Your ref:
Our ref: 24/00721/F
Please ask for: Charlie Collier
Direct dial:
E-mail: borough.planning@west-norfolk.gov.uk

Details: **Proposed front porch at 52 Suffield Way King's Lynn Norfolk PE30 3DL**

PROJECT : 301 DRAWING : 02A DATE : FEB 2024 DRAWING : EXISTING & PROPOSED PLANS & ELEVATIONS SCALE : SHOWN AT A3

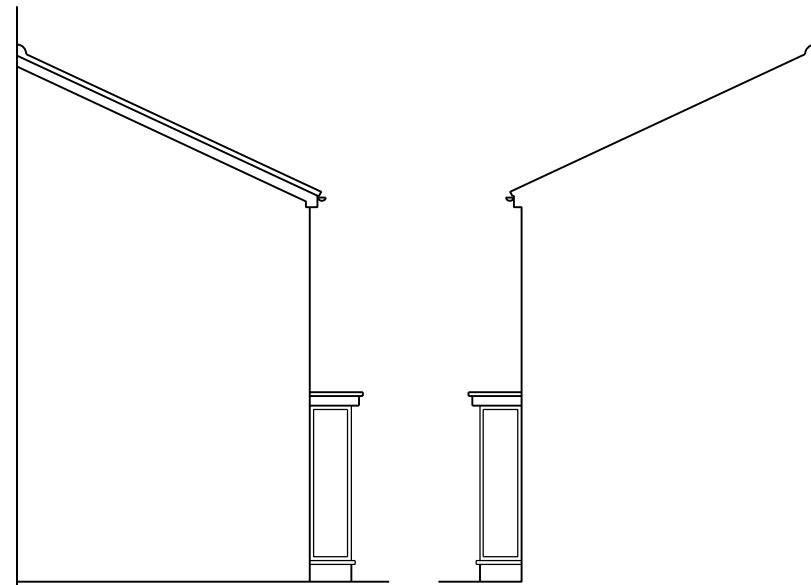
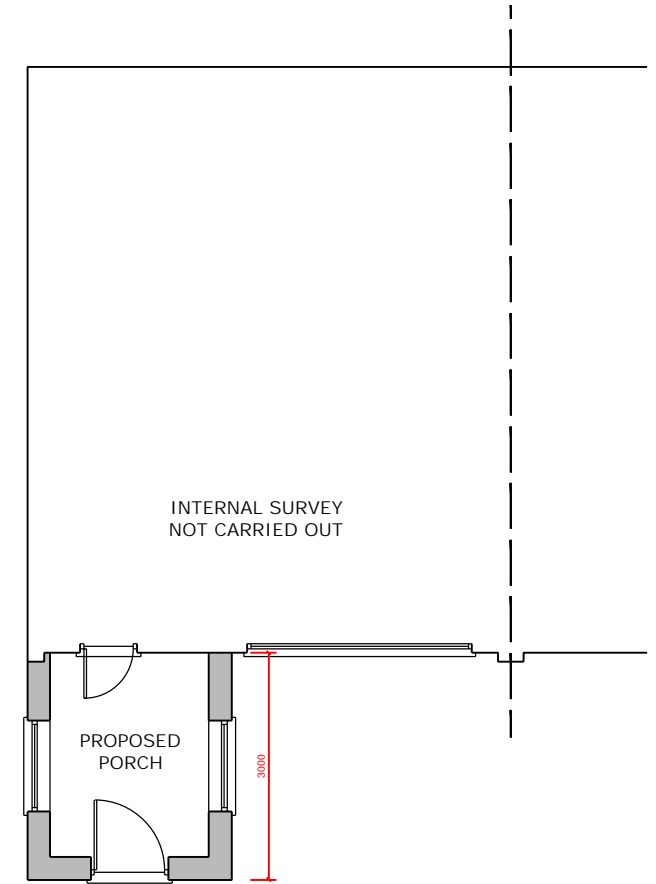
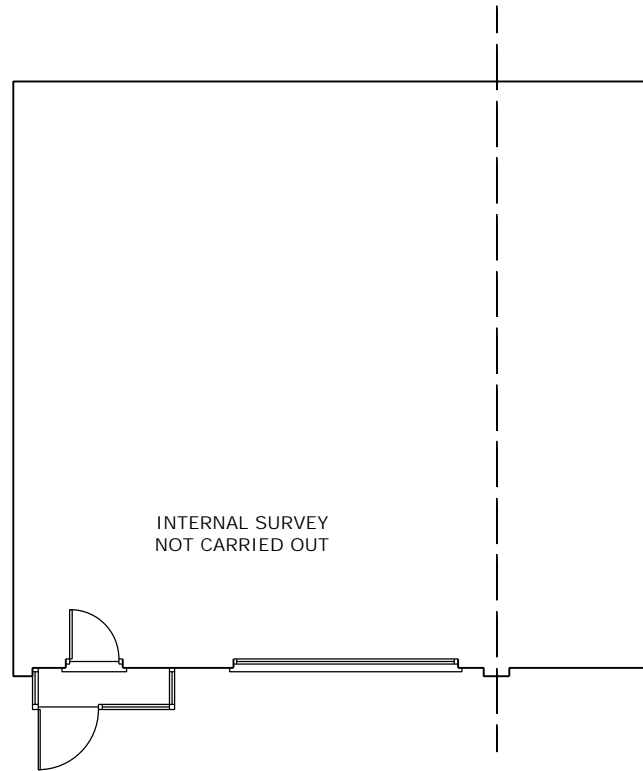
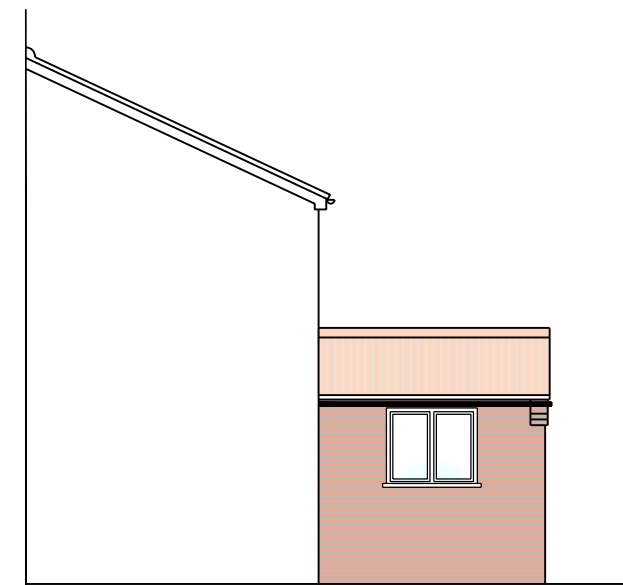
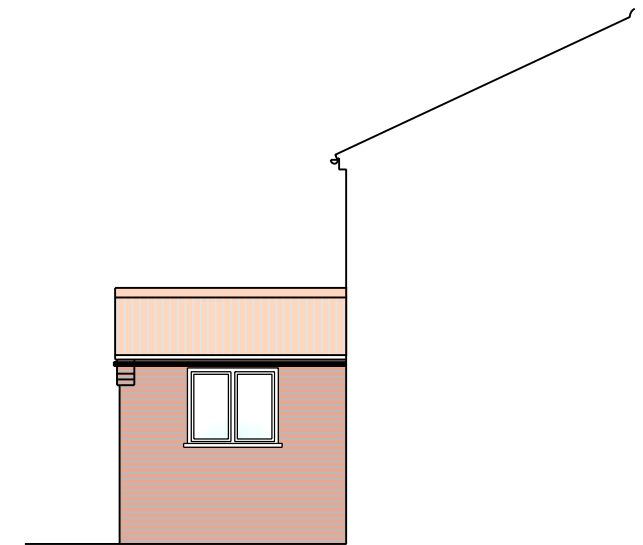
1. A Flood Risk Assessment is required to be submitted with this application, as the site lies within an area at risk of flooding.
2. Please provide drawings to a recognisable scale, showing existing and proposed site levels. If the site levels are to remain unchanged, please provide the drawings annotated as existing and proposed.
